## Application for a Non-Material Amendment Following a Grant of Planning Permission

3/2025/0231

Movement of the Proposed rear entrance door and movement of a window to accomidate this

**03-204 - General-Arrangement\_Plans\_Sheet-02 Proposed Elevations**

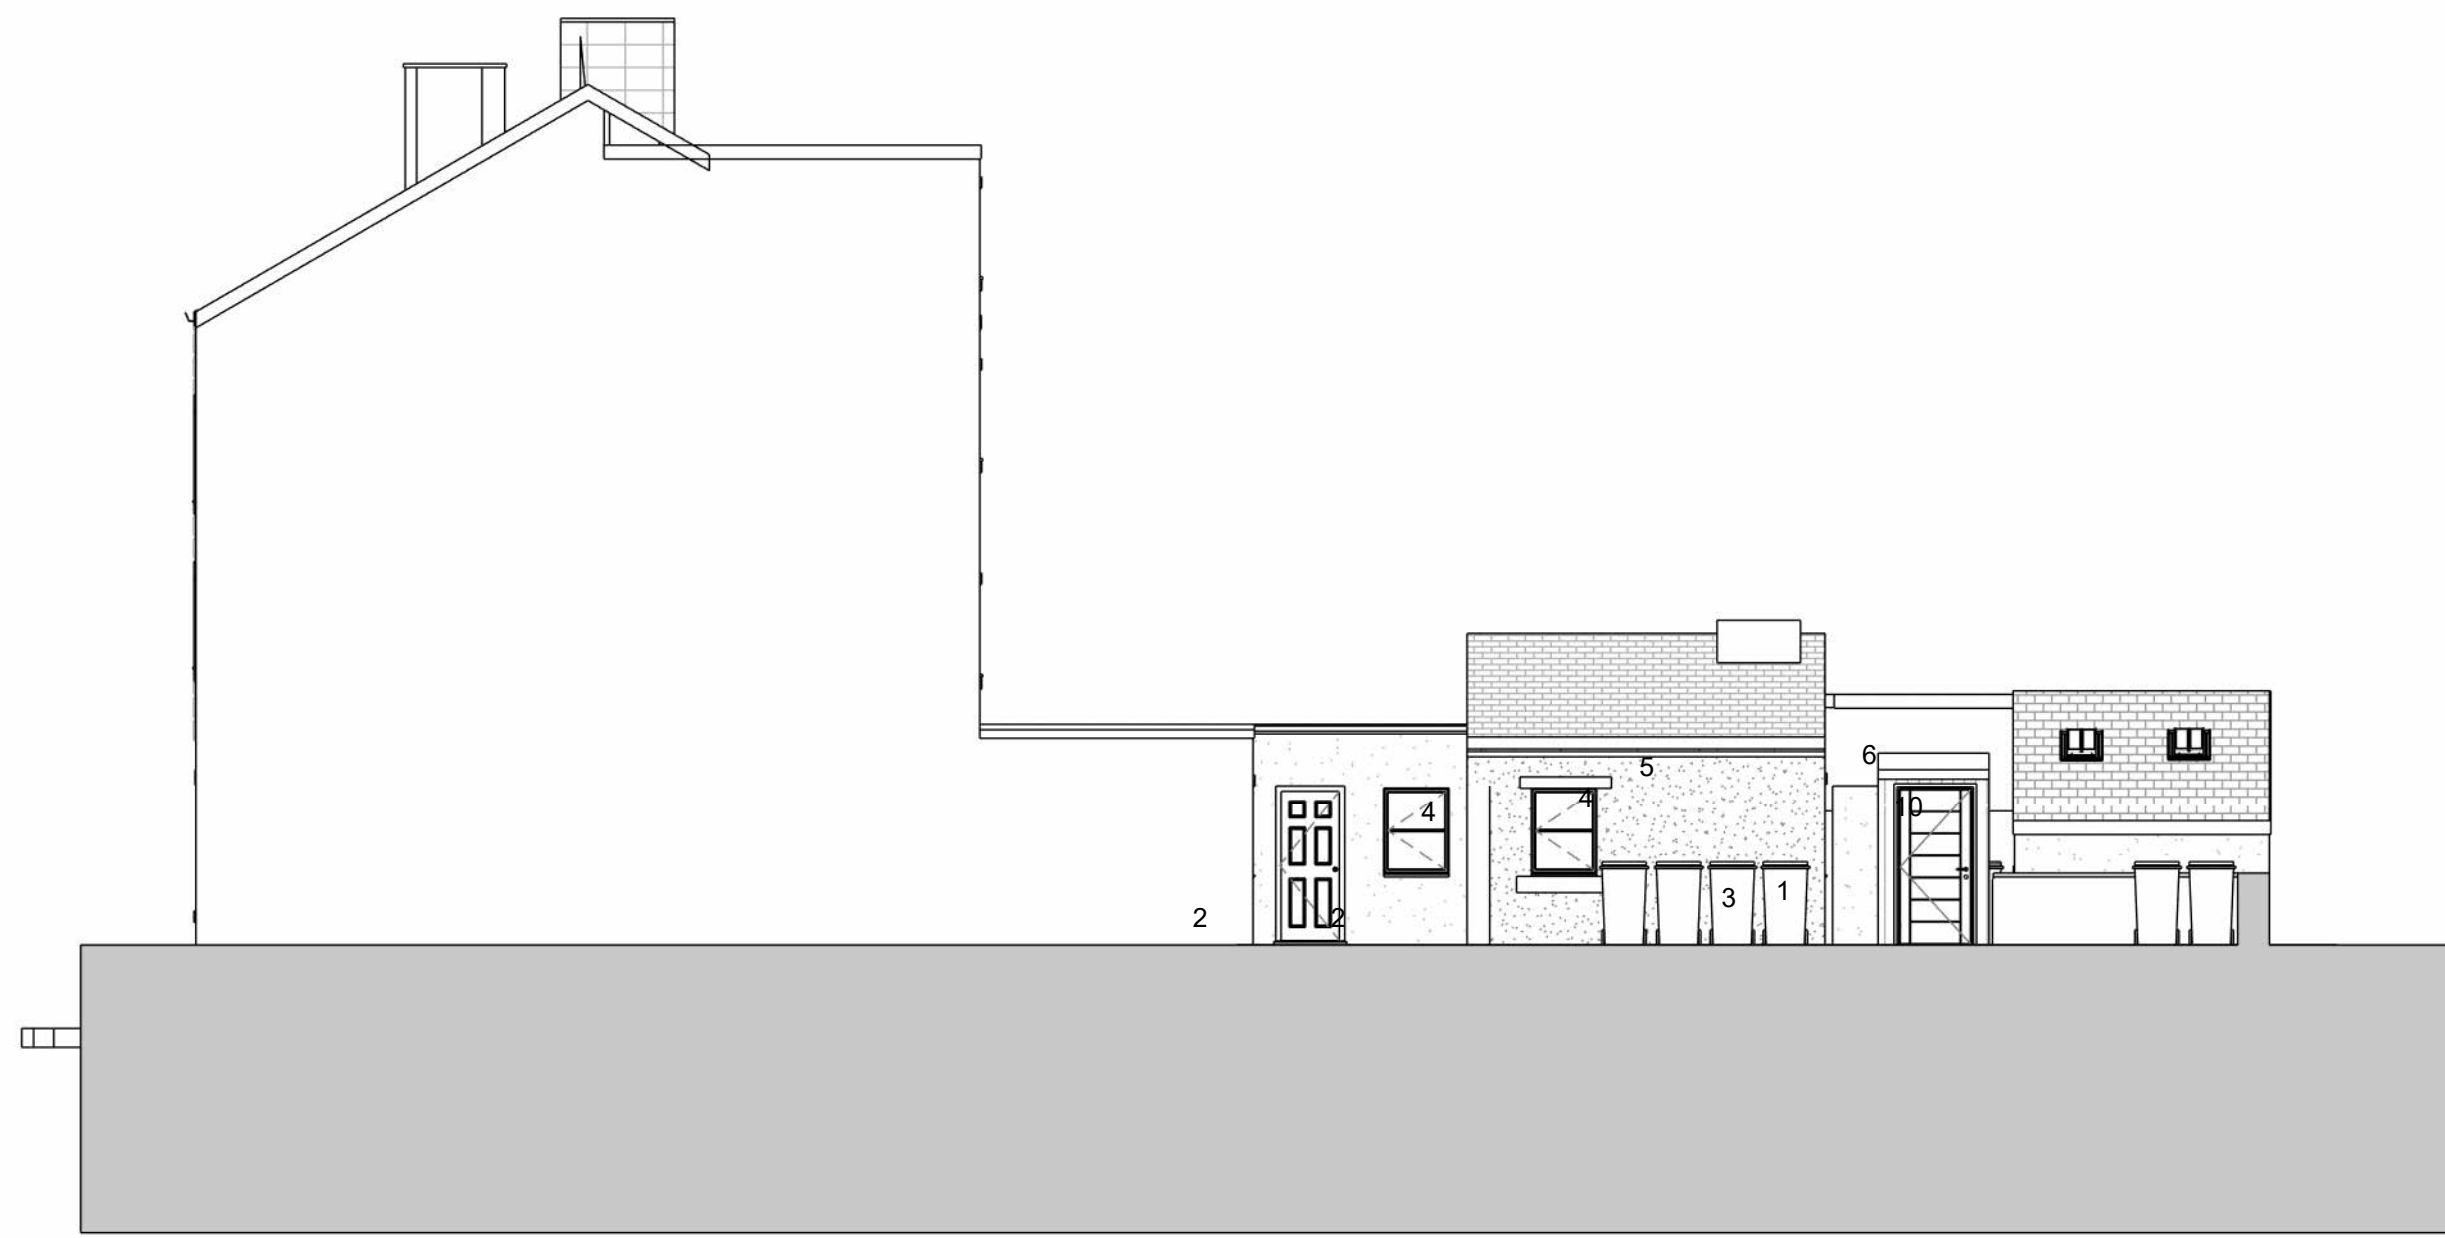
On site constrants mean the original position wont work

Proposed Floor Plans 03-203 Rev P12  
Proposed Elevations 03-204 Rev P11
